**Comments re: 09_0088 Mixed Use Subdivision West Culburra (Concept Plan)
June 2013**

WEST CULBURRA MIXED USE CONCEPT PLAN

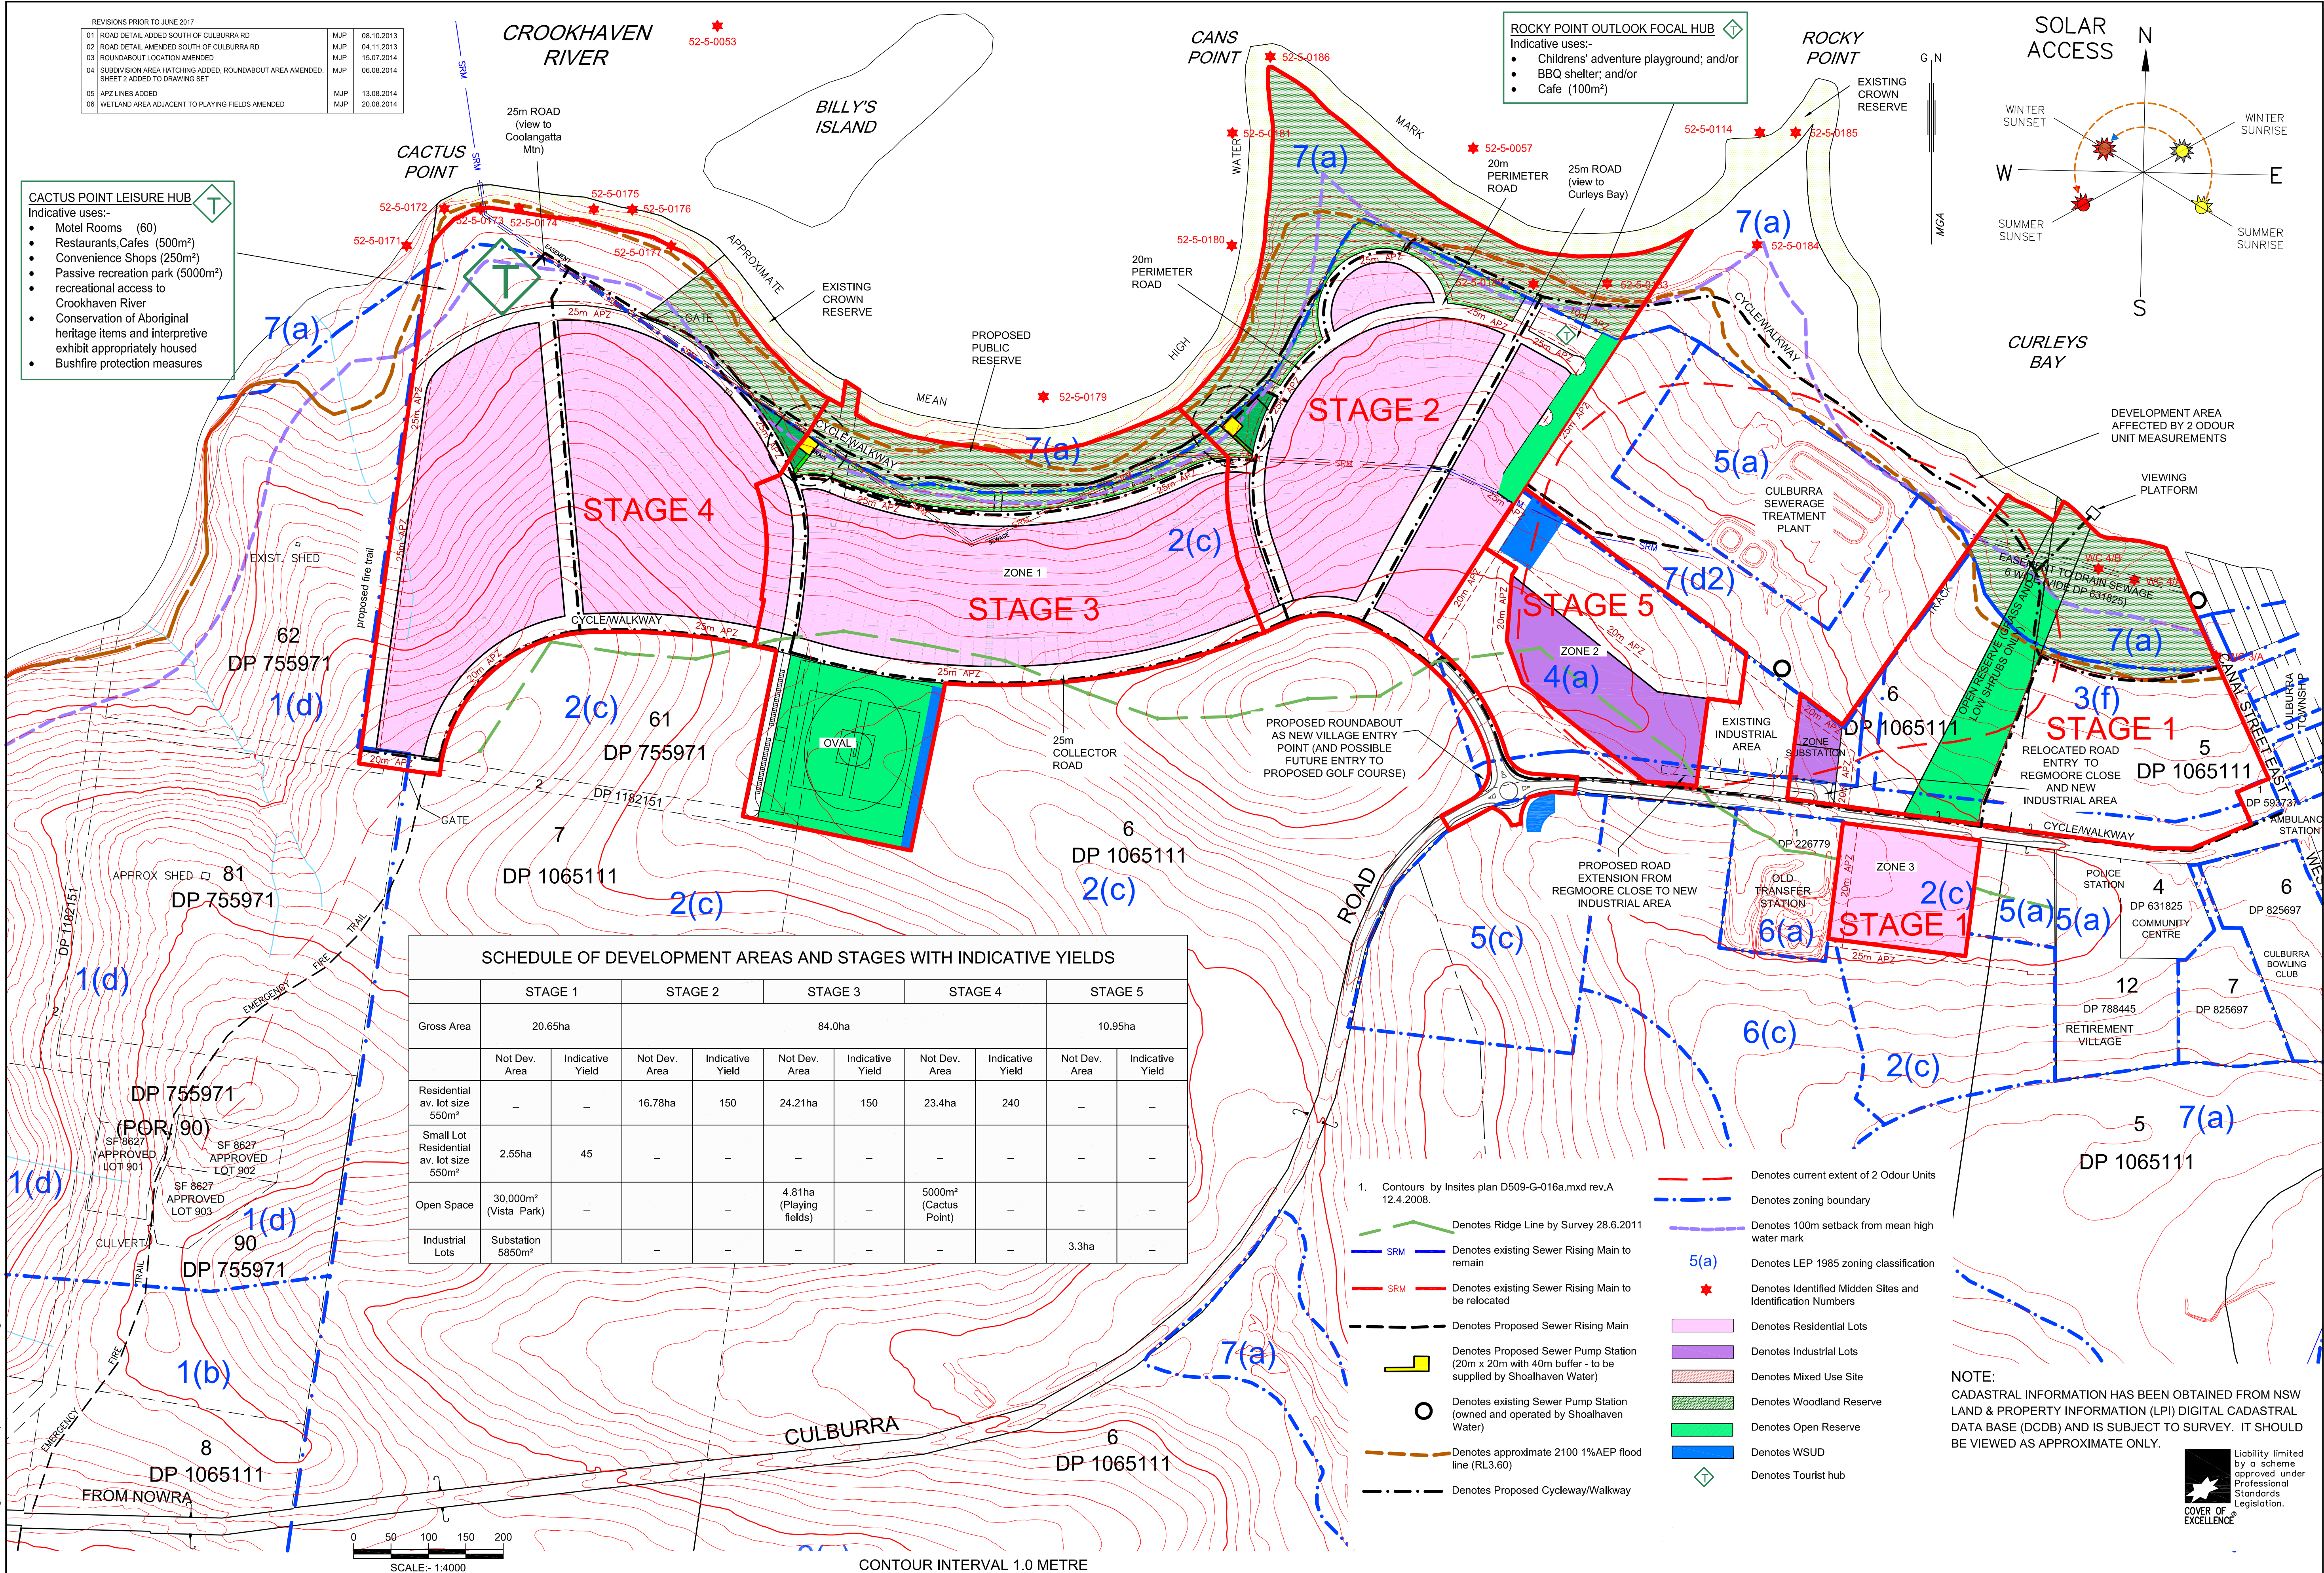
- The only purpose of these trees seems to be to screen the over-sized four-storey buildings proposed for along the roadside, to '*lessen the visual impact of new buildings on adjoining natural landscapes*' (pp44). . In relation to these buildings, the application states that '*the type, bulk and scale of development proposed is considered appropriate for the location.*' This is self-serving rubbish !!! Elsewhere the application states that '*the built form of Culburra Beach is described as low density set in an open landscape of remnant vegetation, lawns and herbaceous bushes*' (pp105) and comments on the '*natural scenic quality of the surrounding areas*'. It is this natural scenic quality that needs to be retained at the entrance to the town.

- Being located at the front door to the town, the proposed four-storey buildings are in a highly visually-sensitive location, and visual amenity needs to be carefully and sensitively managed, rather than dramatically changing the nature of the entrance to the whole town just to suit the developer's interests.

- Consent conditions should require either reduction of the height of the four-storey buildings to something comparable with the nature of Culburra Beach or relocating them to give a better set-back from the main road, so that shorter trees can be used to screen them.

- This riparian land is identified as having high ecological values with 100m of native vegetation to be retained, however the proposal identifies various contradictory functions including an 'active waterfront' and 'leisure hub'; with elements to include cycleways, barbeques, playgrounds, fitness stations, recreational facilities, boat ramps, cafes, restaurants, motels and the like, as well as stormwater runoff treatment systems. How much ecological value and buffering will actually be retained on this riparian land ?????

- The proposal contains no public open space other than this foreshore park and an oval that is to be constructed at a later stage of the proposal. The ecological value of the foreshore land will be destroyed by persistent resident demand for recreational open space for active uses such as playgrounds, ball games, skateboarding, etc.

- Masterplanning and safeguarding of the ecological integrity of this waterfront land should be closely conditioned to ensure protection of its ecological functions. Narrow linear bushland remnants such as what is proposed are highly susceptible to edge effects that push into the bushland and erode its ecological values. Maybe the park needs to be 150m wide with the additional width allocated to recreational pursuits.
